**Planning Application Reference Number:** 324113

**Subject:** Submission on the Construction of an open-cycle gas turbine power plant, primarily fuelled by Natural Gas, Above Ground Installation and ancillary development

**Location:** Pollnagroagh and Rathmorrissy (Townlands), Athenry, Co. Galway

**Applicant:** Bord Gáis Energy Limited

Purpose		PLANNING			
Title		SITE ACCESS SIGHTLINES			
Original Scale	Design/Drawn	Checked	Authorised		
SHOWN at A1	PS	ND	AJB		
Date	Date	Date	Date		
01.12.25	01.12.25	01.12.25	01.12.25		
Status	Drawing Number	Rev			
A2	PEK3-ATK-ZZ-01-DR-CE-901200	0

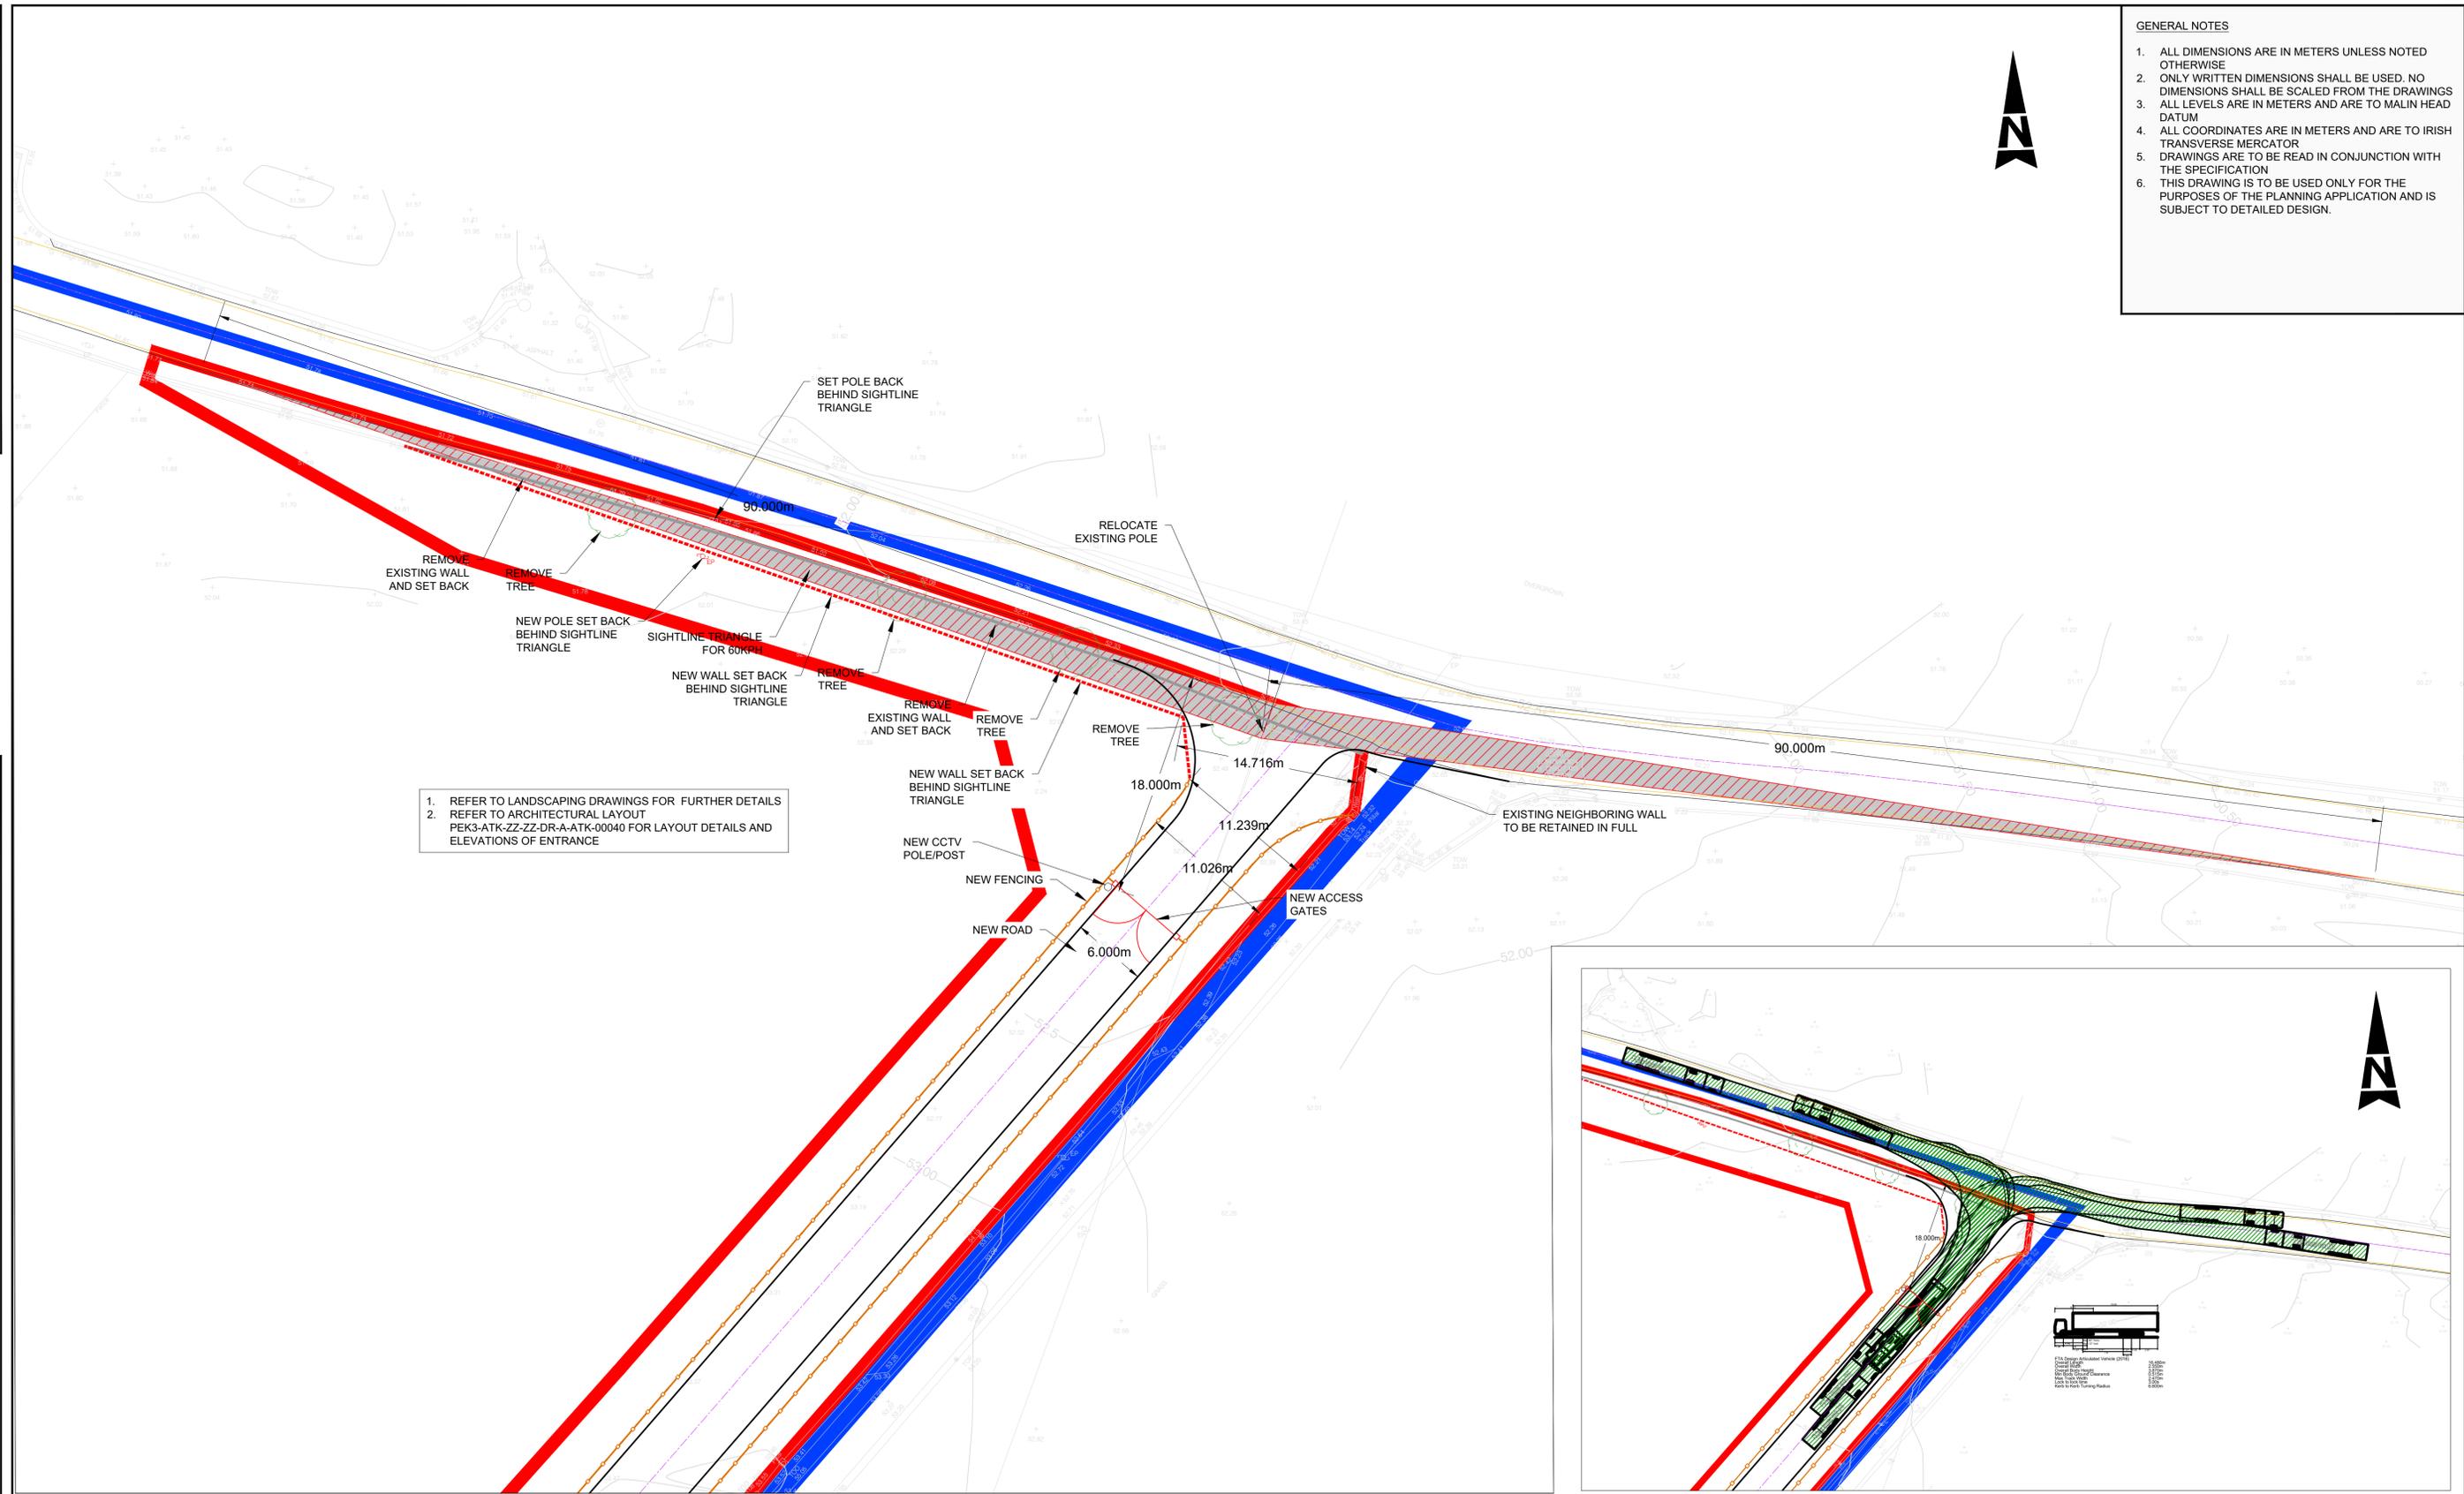
My home is located on the L3103 which I use on a regular basis. The proposed site entrance is located on an exceptionally dangerous section of the L3103. Establishing an access point at this specific location introduces an unacceptable level of risk due to several compounding hazards:

- Severely Restricted Width: The road is currently too narrow to safely permit two Heavy Goods Vehicles to pass simultaneously.
- Absence of a Hard Shoulder: There is no safe refuge or margin for error for manoeuvring vehicles.

- Critically Poor Visibility: The immediate area is affected by blind dips and blind corners, severely compromising driver sightlines.

These immediate dangers constitute a severe threat to public safety and require urgent and mandatory remediation. In addition to these existing hazards, local roads are not designed to accommodate sustained industrial traffic. The interaction between heavy goods vehicles, farm machinery, and everyday residential traffic creates a complex and potentially dangerous road environment. The introduction of additional industrial traffic, including diesel deliveries and construction vehicles, further compounds these risks.
